KIRKLEES METROPOLITAN COUNCIL INVESTMENT & REGENERATION SERVICE

DELEGATED DECISION TO DETERMINE PLANNING APPLICATIONS

Reference No:	2021/62/94744/W
Site Address:	23, New Hey Road, Marsh, Huddersfield, HD3 4AL
Description:	Demolition of detached garage and erection of front porch, two storey side, and single and two storey rear extensions
Recommending Officer:	Laura Yeadon

DECISION – CONDITIONAL FULL PERMISSION

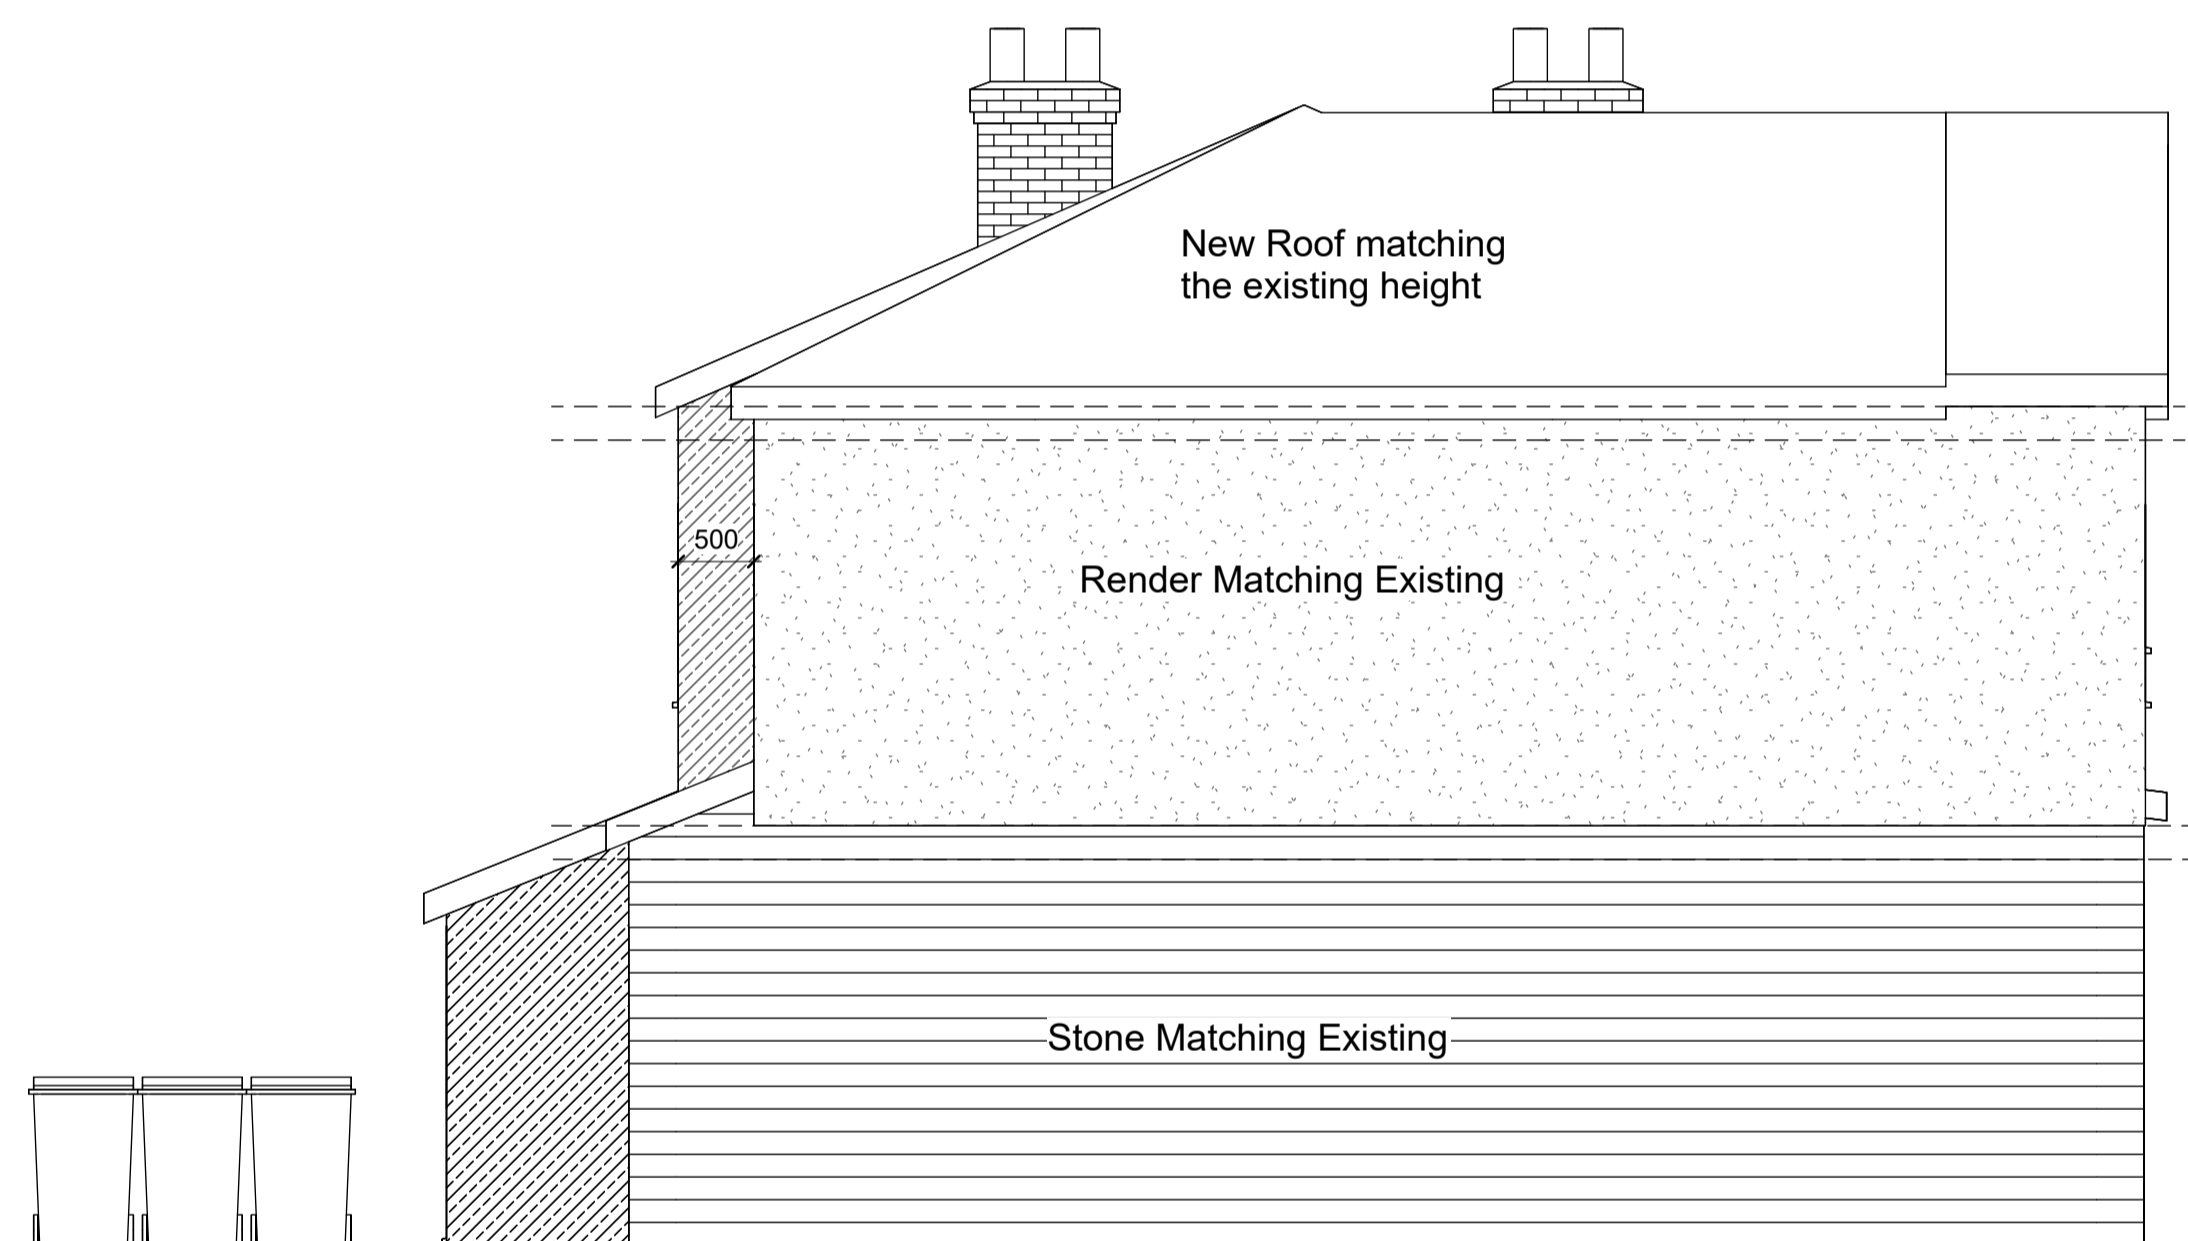
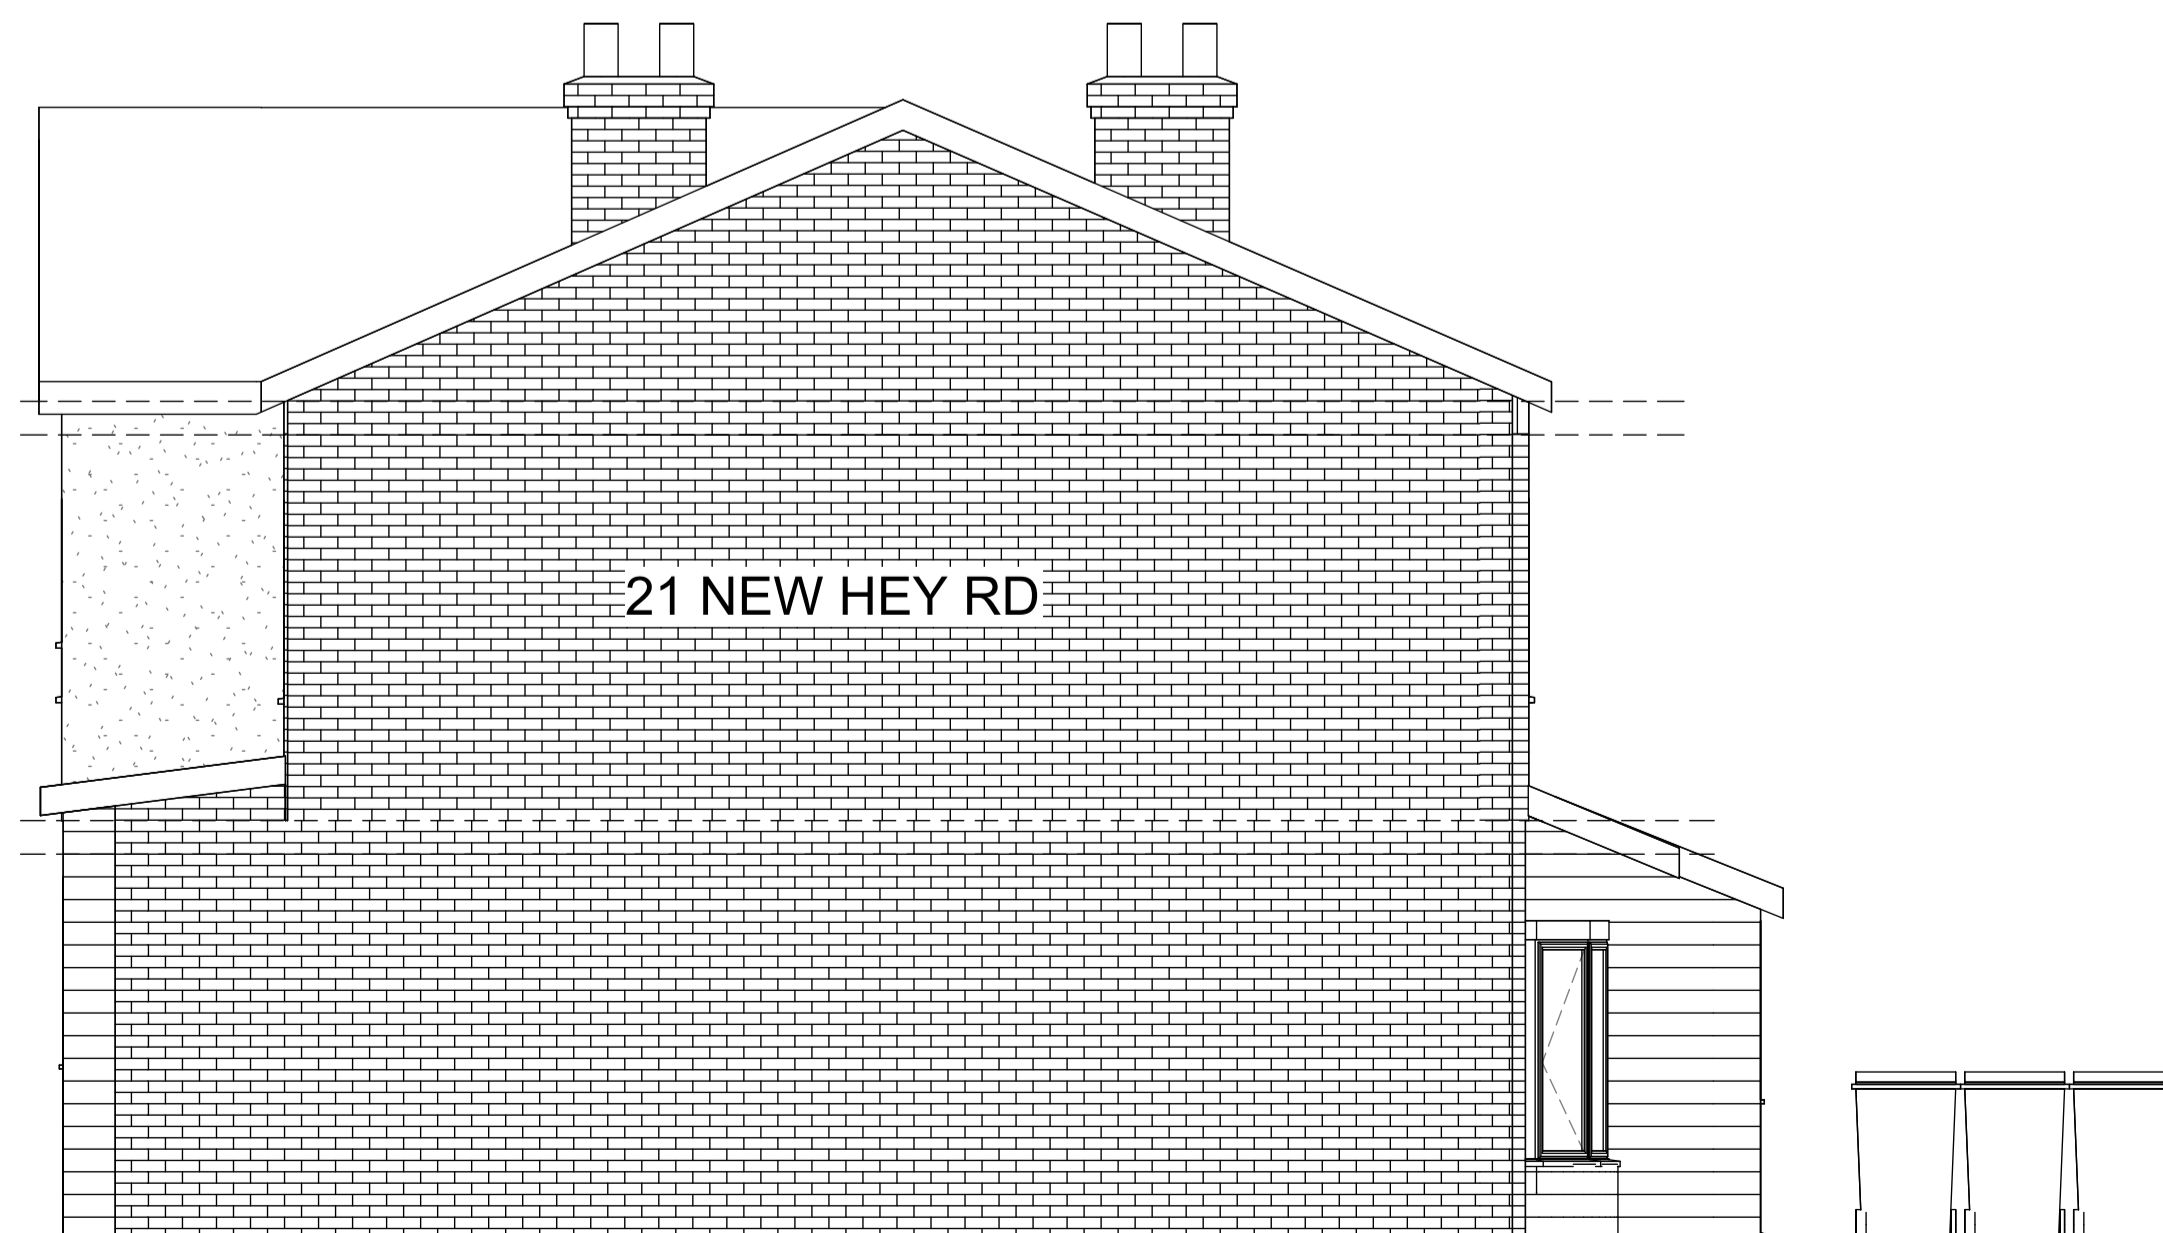
- The plans make it clear that the side extension wall of the extension comes to the border with the neighbouring property which means the eaves and guttering with overhang the shared boundary

Concerns have been raised with regard to overhanging eaves and guttering. A note can be attached to the decision notice stating that planning permission does not override any ownership rights to any land outside the ownership boundary of the site nor does it convey any authority to enter onto such land or into any building upon it or over it.

NOTE: The guttering and eaves appear to have the potential to overhang the boundary. It should be noted that this planning permission does not override any ownership rights to any land outside the ownership boundary of the site nor does it convey any authority to enter onto such land or into any building upon it or over it.
